# CITY OF ALBUQUERQUE

February 20, 2018

**Re: Village at Avalon, 601 90<sup>th</sup> St. NW Buildings 1, 2, 3, 9, & 10**  
**Request for Certificate of Occupancy**  
**Transportation Development Final Inspection**  
Engineer's Stamp dated 4-8-16 (K09D040)  
Certification dated 2-20-18

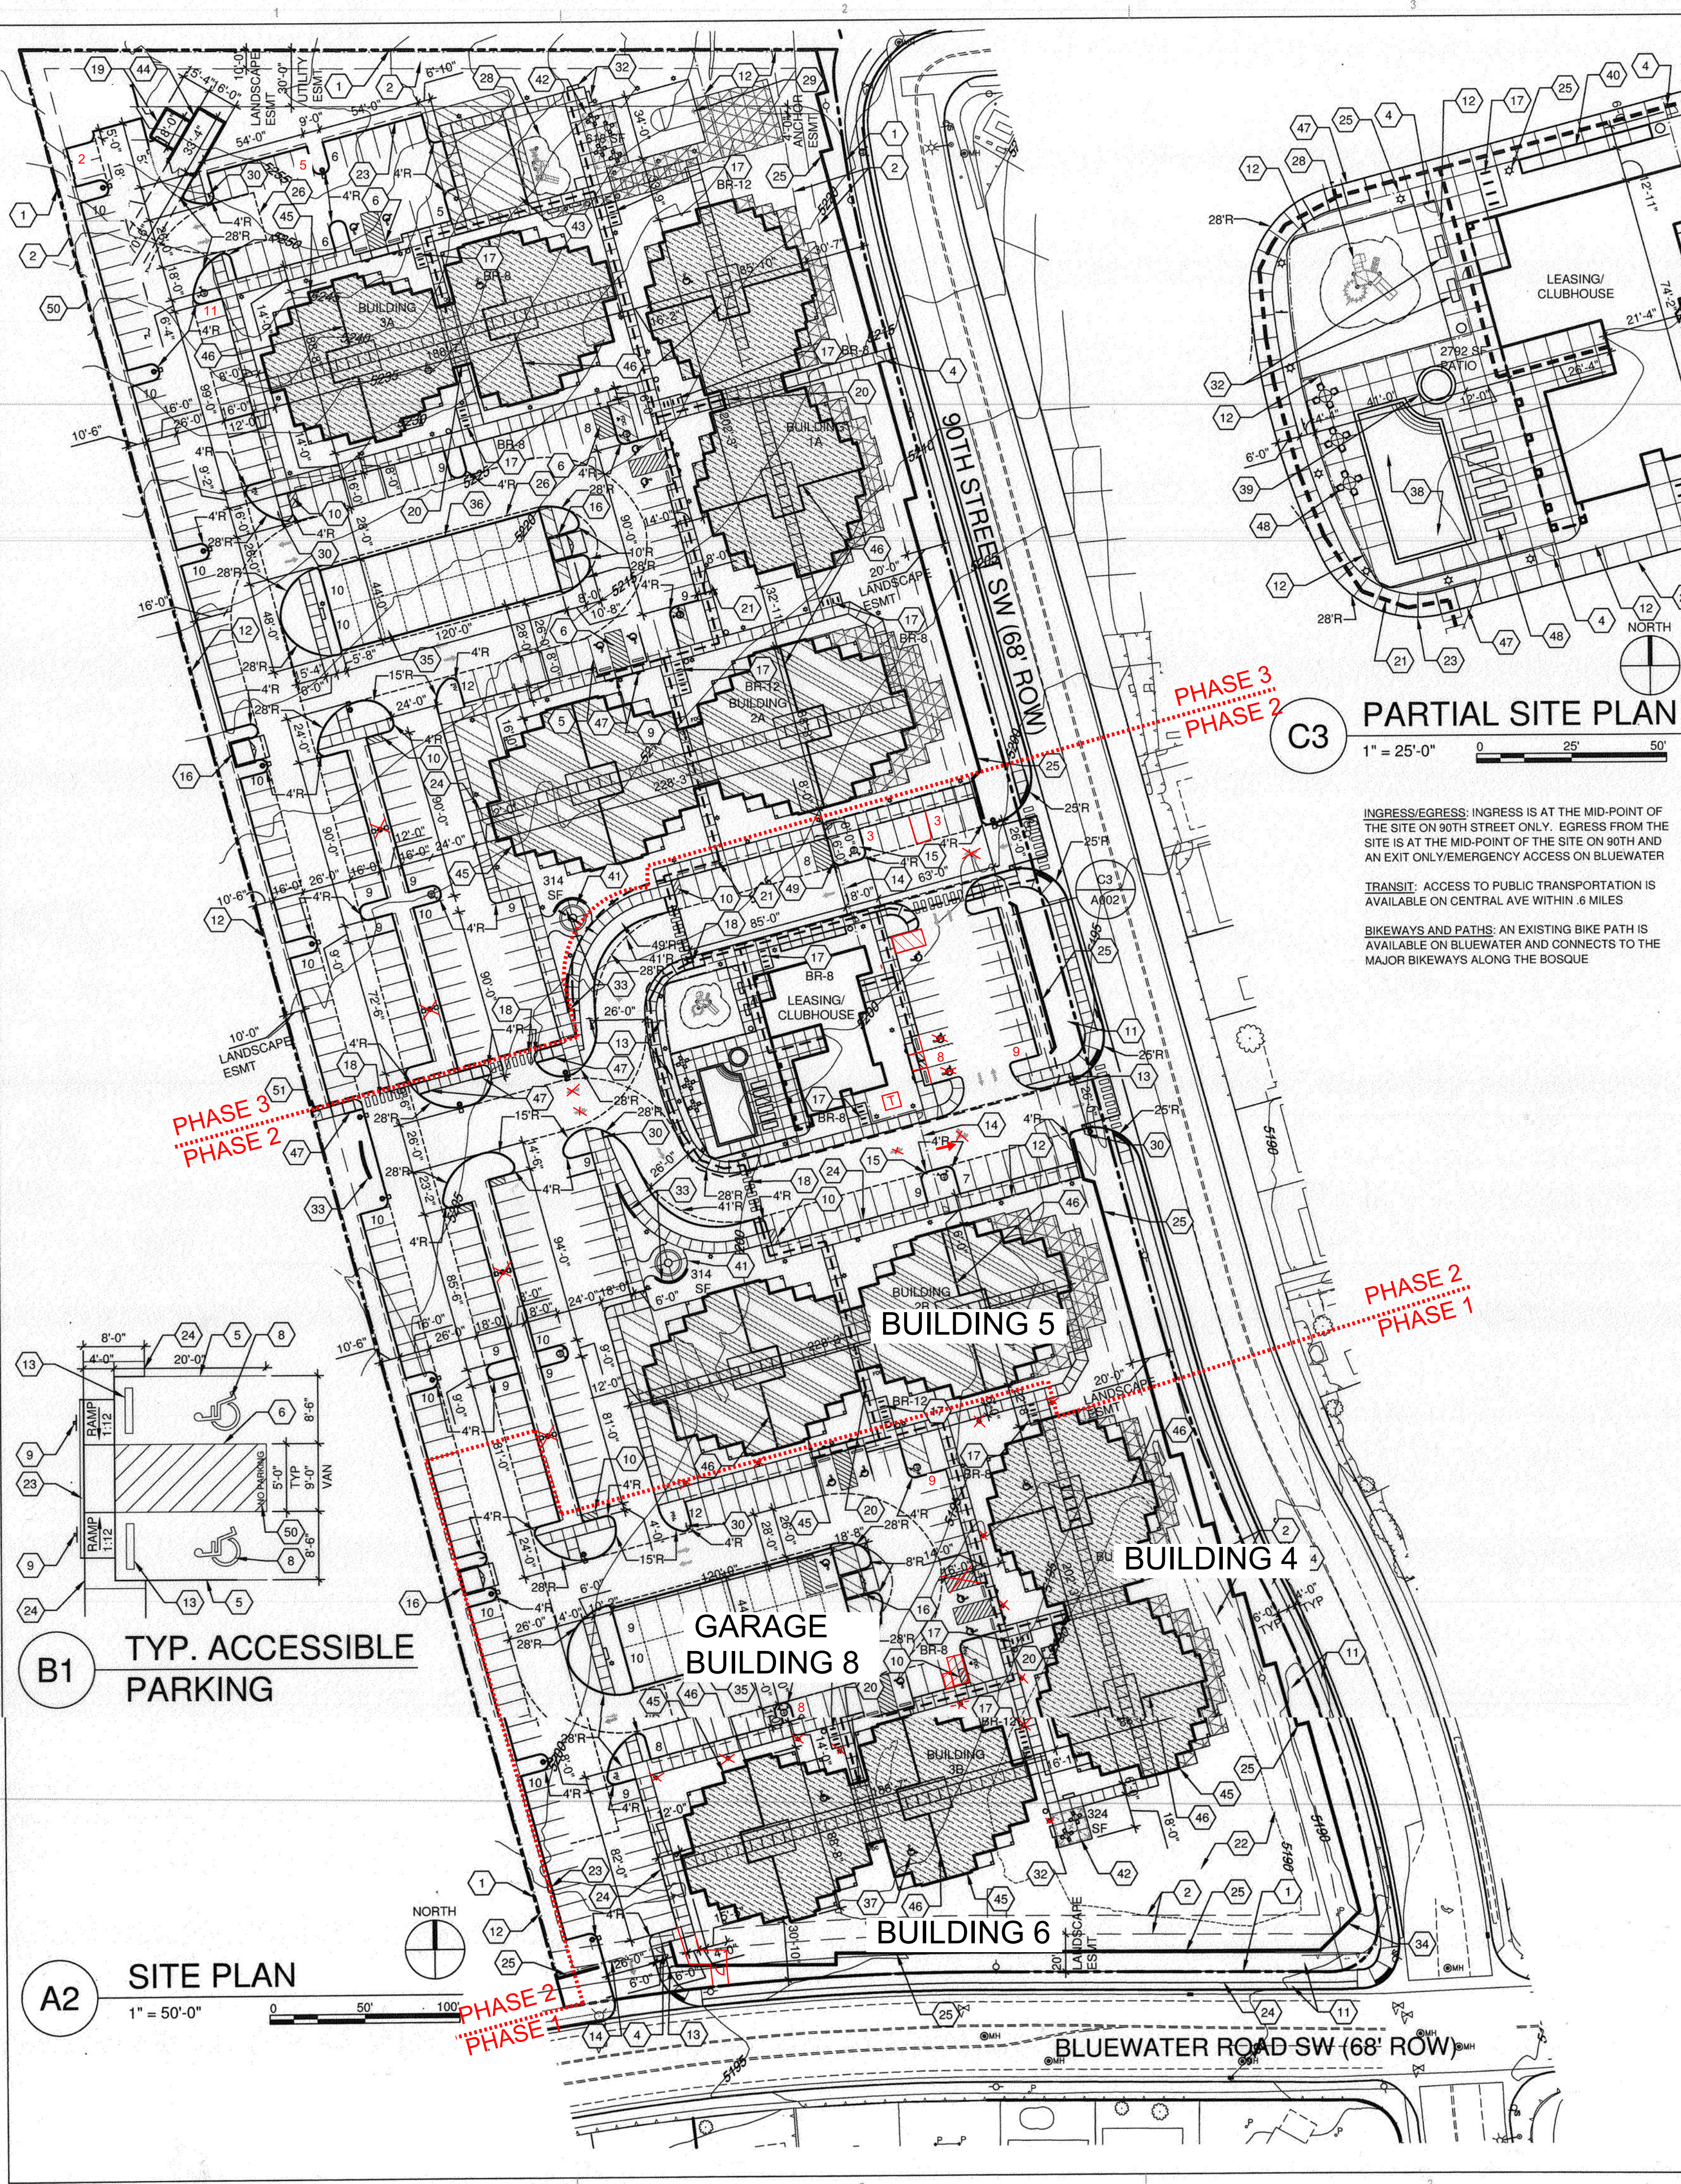
- Changes to the site such as the removal of painted cross walk and site lighting changes require an approval administrative amendment.
- All stop signs must be constructed per the plan prior to the final CO.
